CITY OF ALBUQUE

December 6, 2023

**Re: Calle Cuarta Townhomes at 420 Fitzgerald Road NW
Erosion and Sediment Control Plan for Work Order
Engineer's Stamp Date 3/9/2023 (G14E097)**

SHEET:
**3 - GENERAL
NOTES**

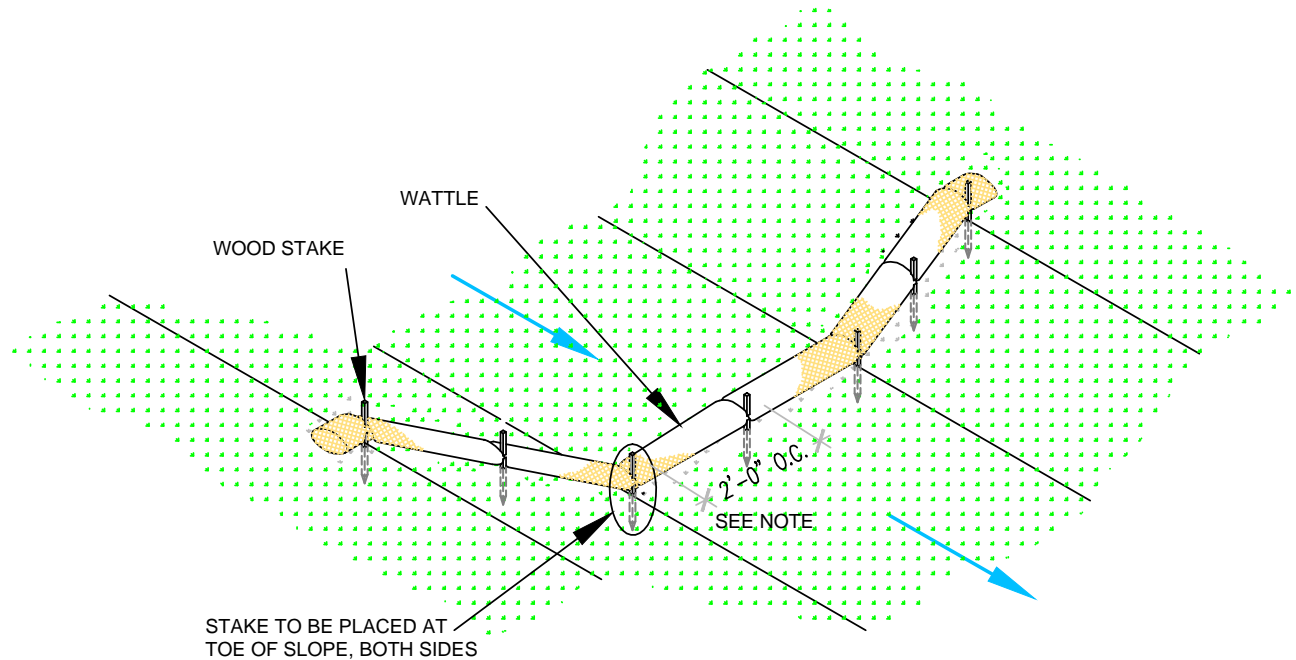
4. The sheet numbers of the first three sheets are missing and should be added.
5. The City Standard Notes (March 24, 2021) on Sheet 3 are not current and need to be revised to the 6/16/23 version (attached).

SHEET:
8

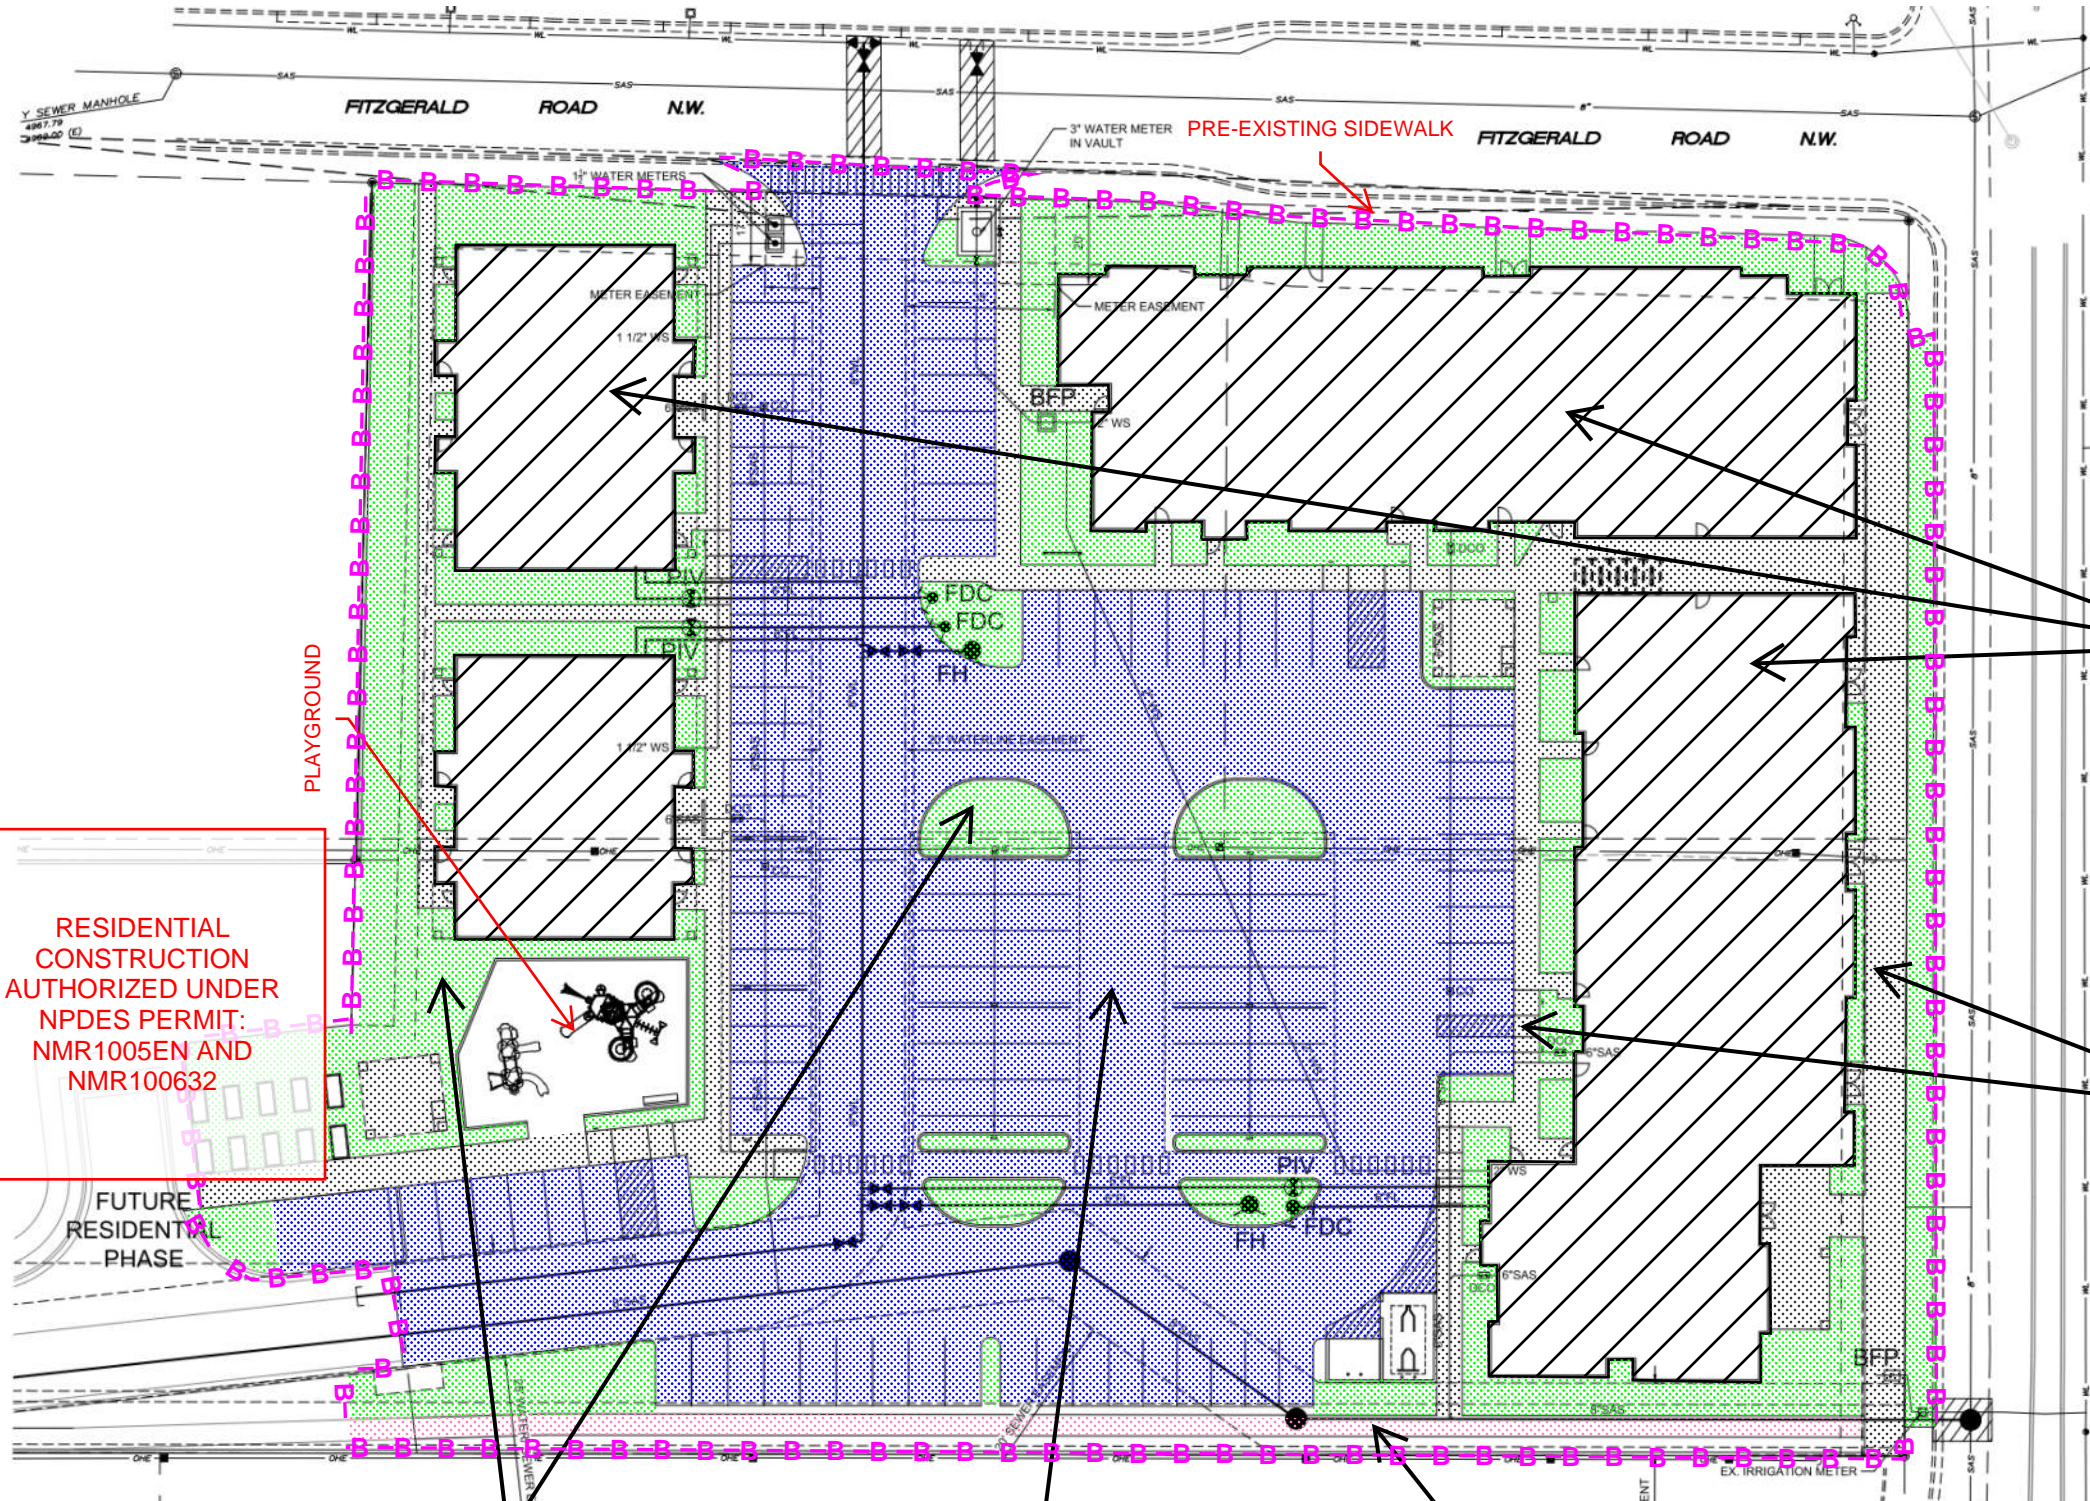
3. Since this plan doesn't provide a phase of BMPs for the Building Permits on the townhome lots, a separate NOI and ESC Plan submittal will be required for that phase of the development. The notes on sheets 8 and 9 indicate a variety of circumstances that may satisfy CGP 8.2 "Conditions for Terminating CGP Coverage". Doesn't Yes Calle Cuarta TH, LLC know who will build the townhouses and when, so the sequence of construction can be better defined? If so, then the notes on sheets 8 & 9 should be coordinated with the sequence/phasing plan on sheet 2.
